I am writing this letter to accompany the Prior Approval Planning Application Submission I am making, dated 15th March 2021. The submission will be for the erection of a single-storey rear extension, projecting to 4.0m, with a flat roof form giving a maximum eaves height of 3.0m. This development would allow for an increase in living space for a family of 4 and most importantly allows for additional hygiene and toilet facilities.

This submission follows a previous application (reference number: 21/10083/HHNOT) which was refused by the East Riding of Yorkshire Council on the grounds of overshadowing and dominance over a neighbouring property. Constructive feedback was sought and obtained (in writing) by the planning department and therefore changes have been made to the proposed development.

PROPOSED EAST ELEVATION

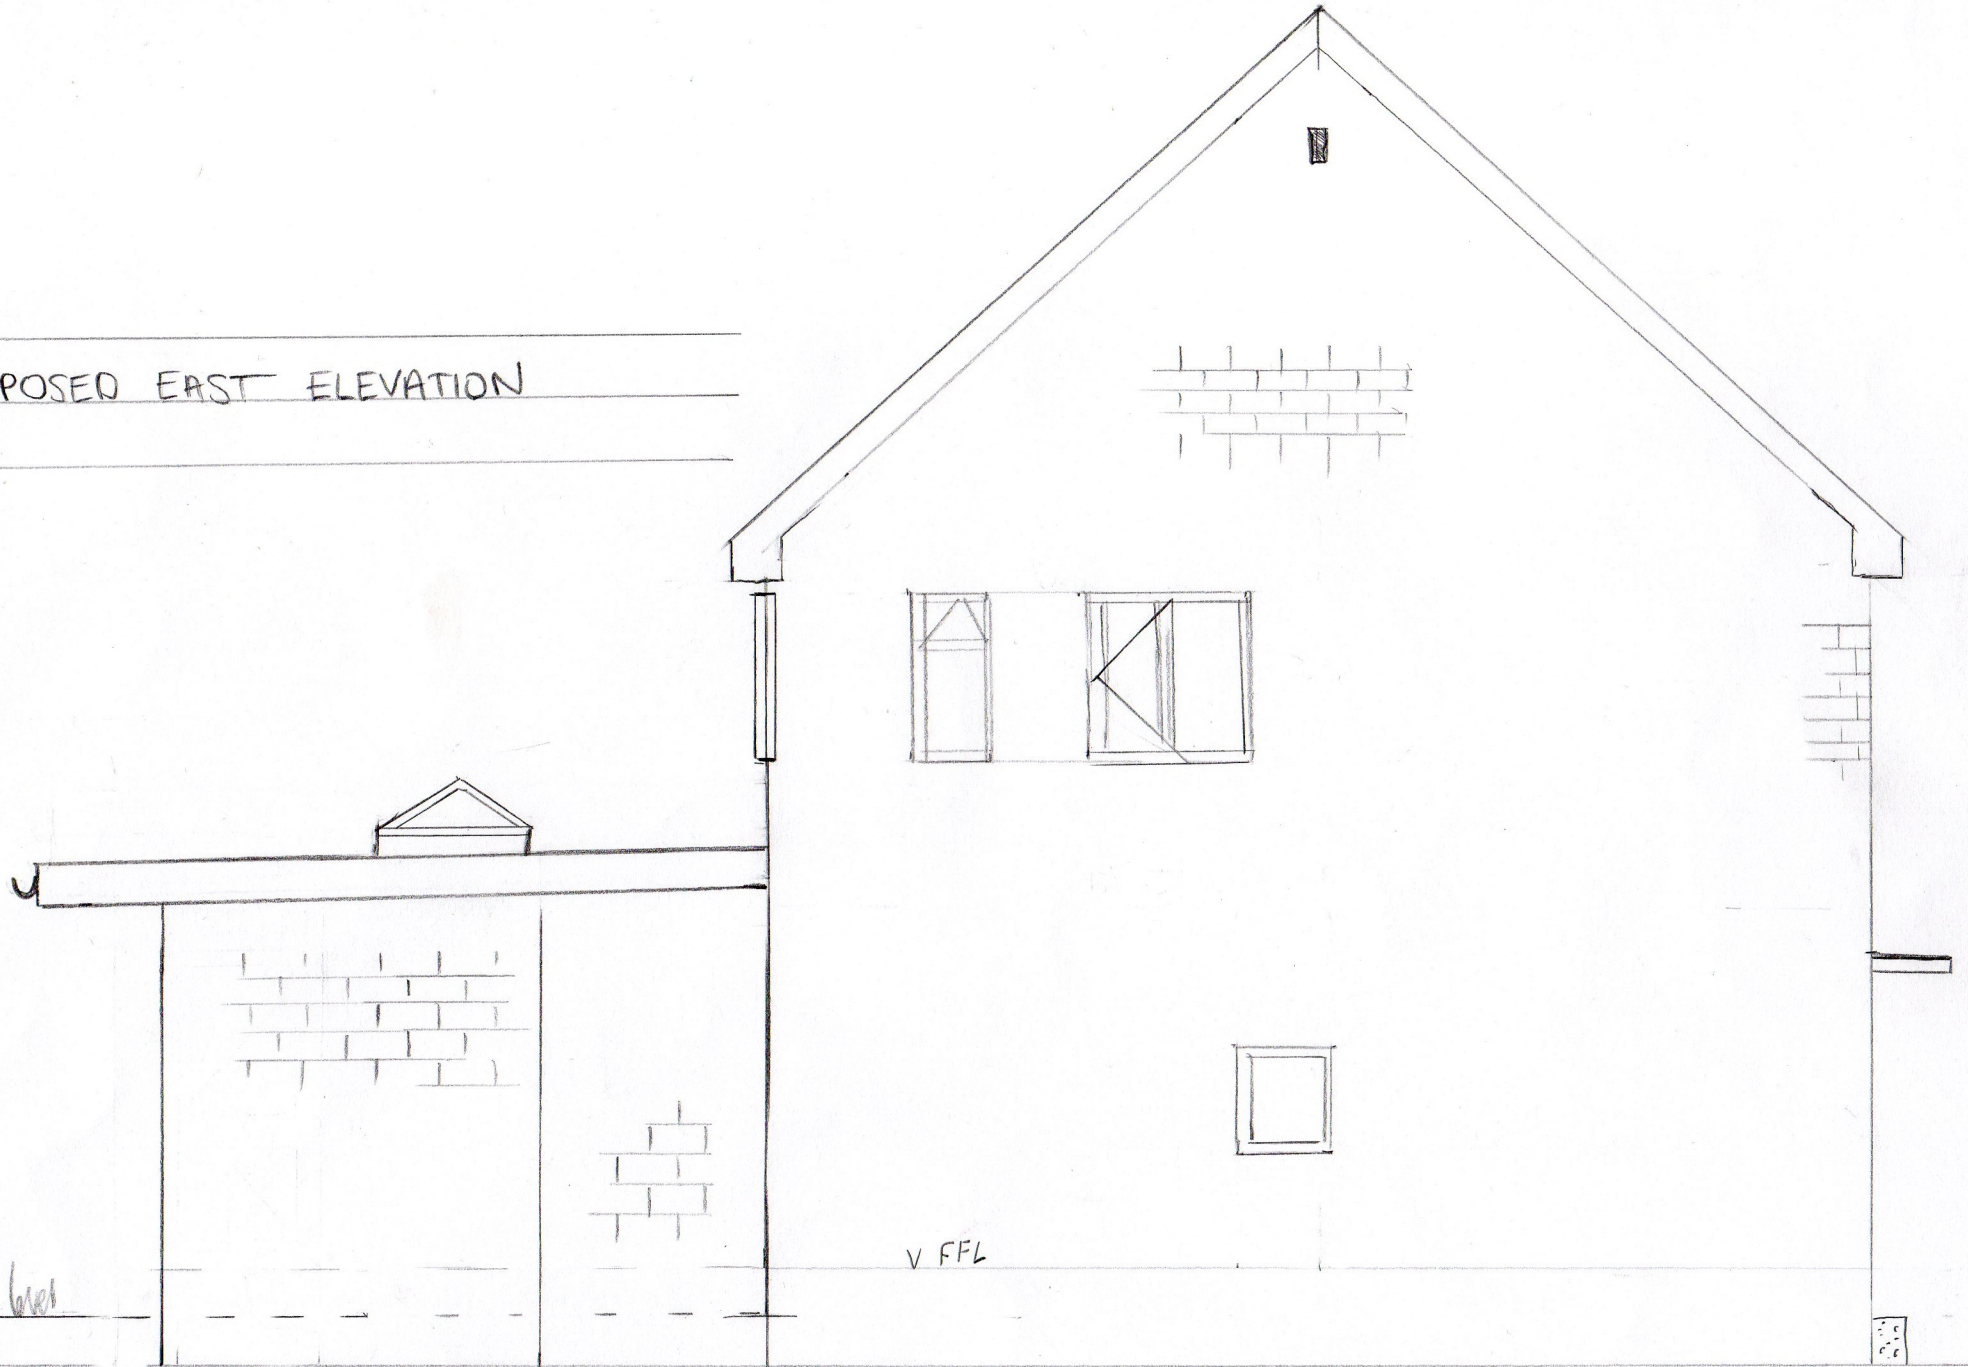
- The proposal will now extend to 4.0m, instead of 4.3m.
- The proposal will be situated away from the shared boundary with 29 White Gap Road by a distance of 500 mm.

These changes now ensure the development would be in accordance with the provisions of policy ENV1 of the East Riding Local Plan Strategy Document and paragraph 127 of the NPPF, thus mitigating the impact to the amenity of neighbouring properties.
